From: Clerk [REDACTED]
Sent: 30 May 2019 12:54
To: Planning.Responses
Subject: RE: Planning Consultation on: BN/31/19/HH

APPLICATION NO: BN/31/19/HH
Registered: 14th May 2019
Site Address: 3 Highview Road Eastergate PO20 3XB
Grid Reference: 494706 105371
Description of Works: Single storey front porch and living extension.

PROPOSED GROUND FLOOR PLAN

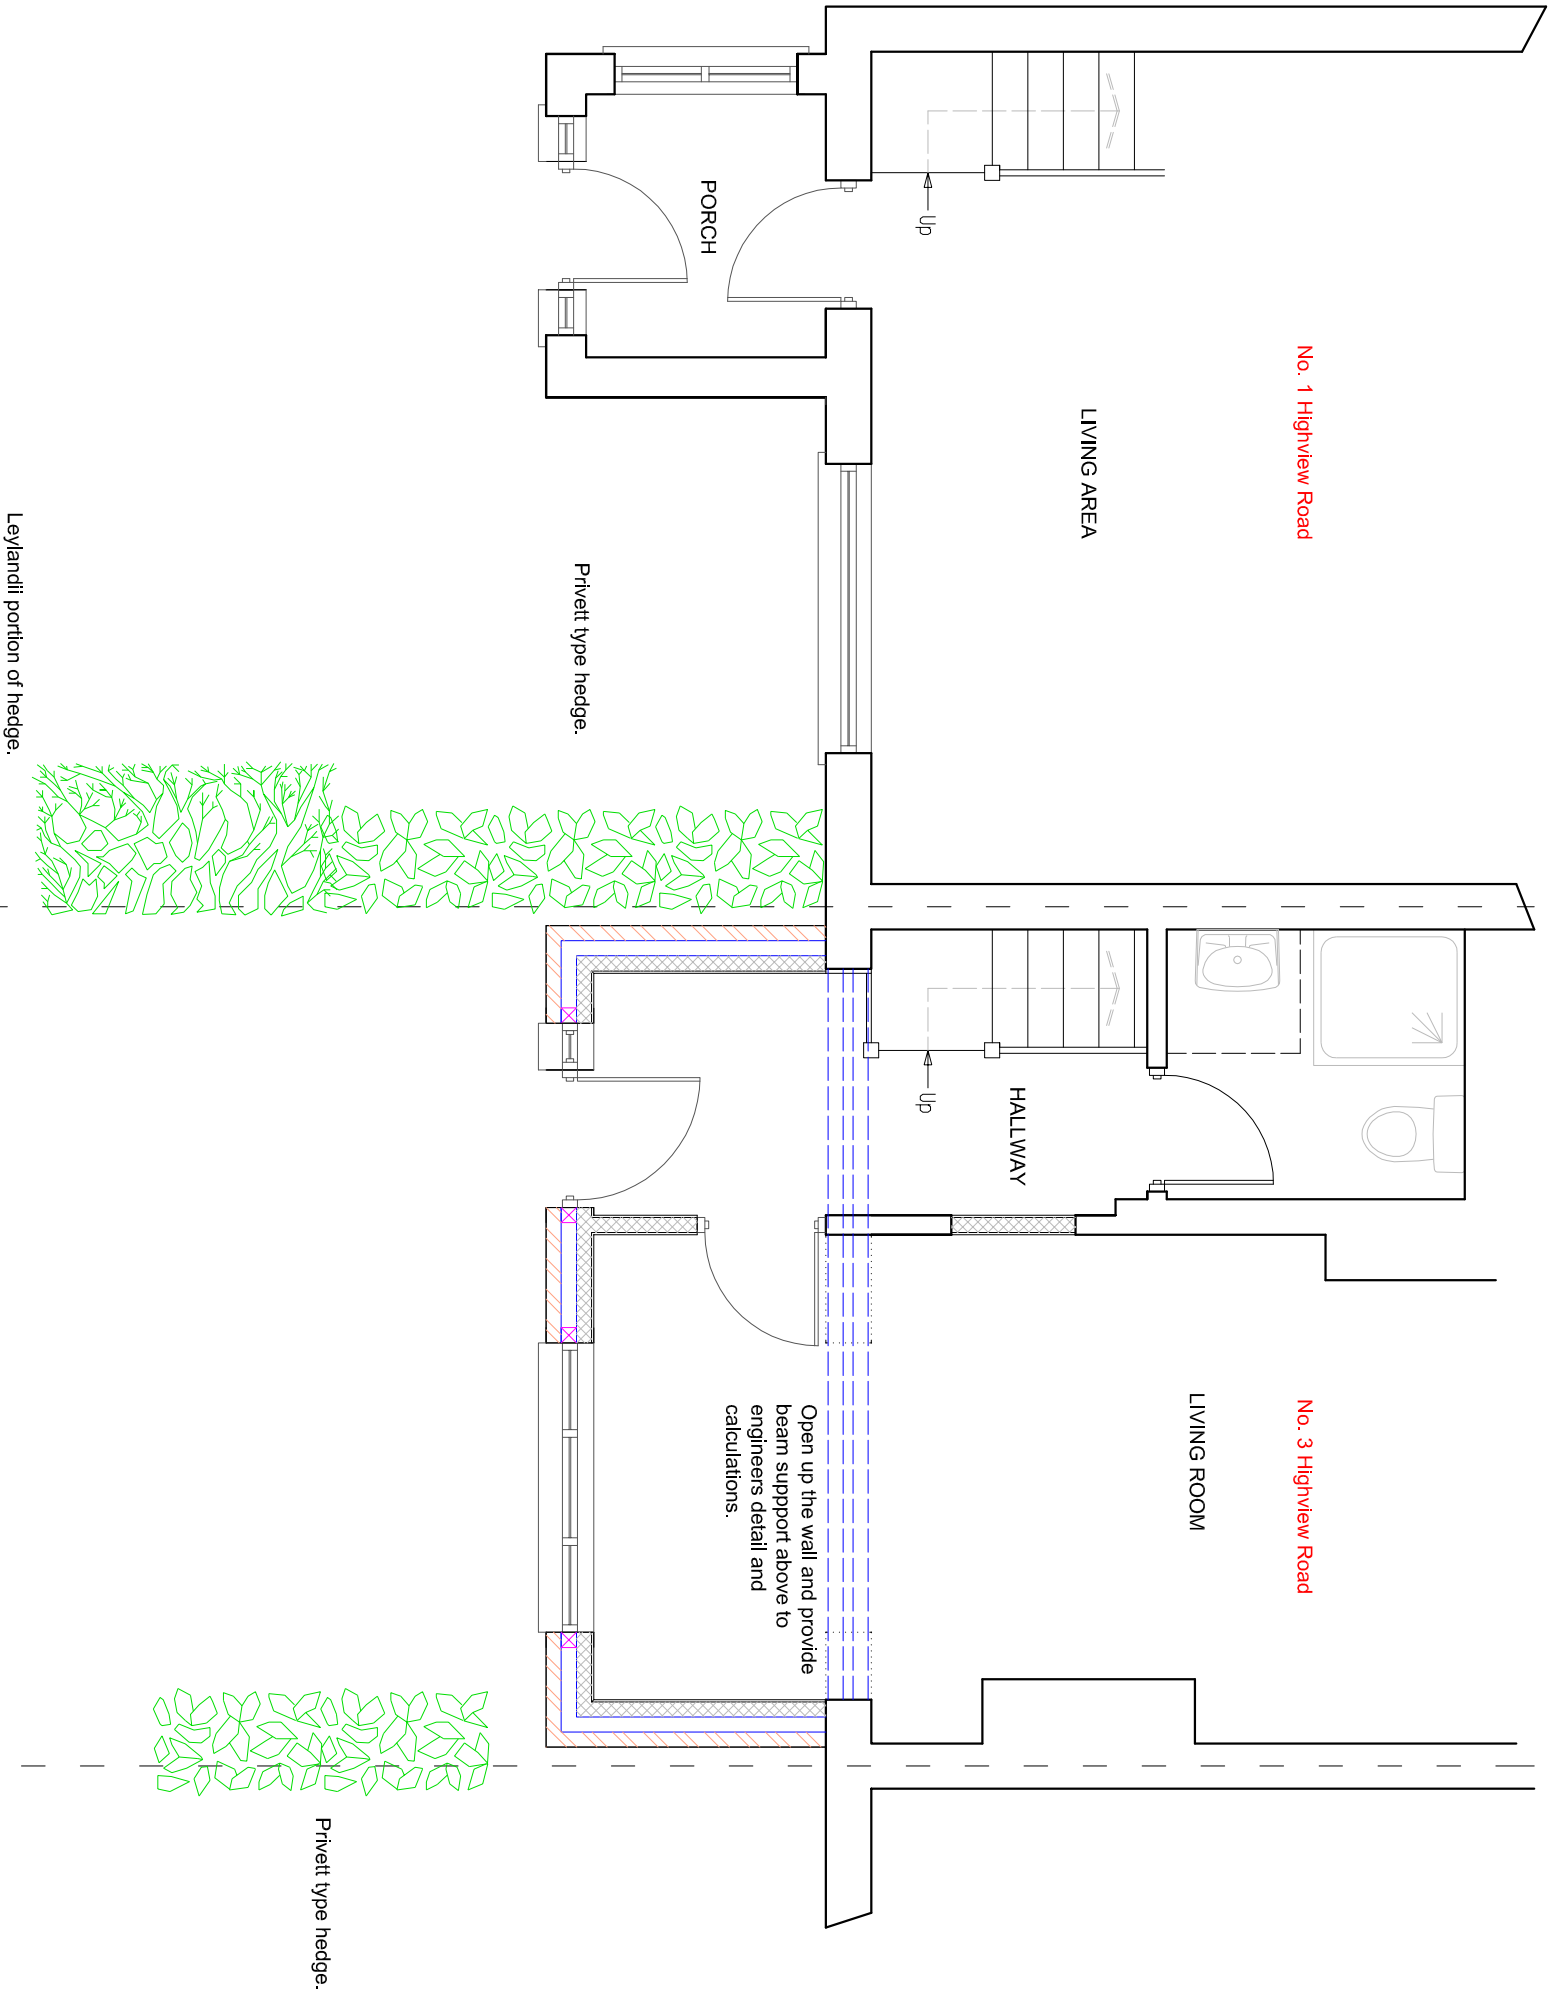
At a meeting of the Barnham & Eastergate Parish Council's Planning & Environment Committee held on 28th May the Council resolved to raise an objection in respect of this application in that the proposed extension would be forward of the existing building line and would certainly have a significant impact on the street scene and the neighbouring properties.
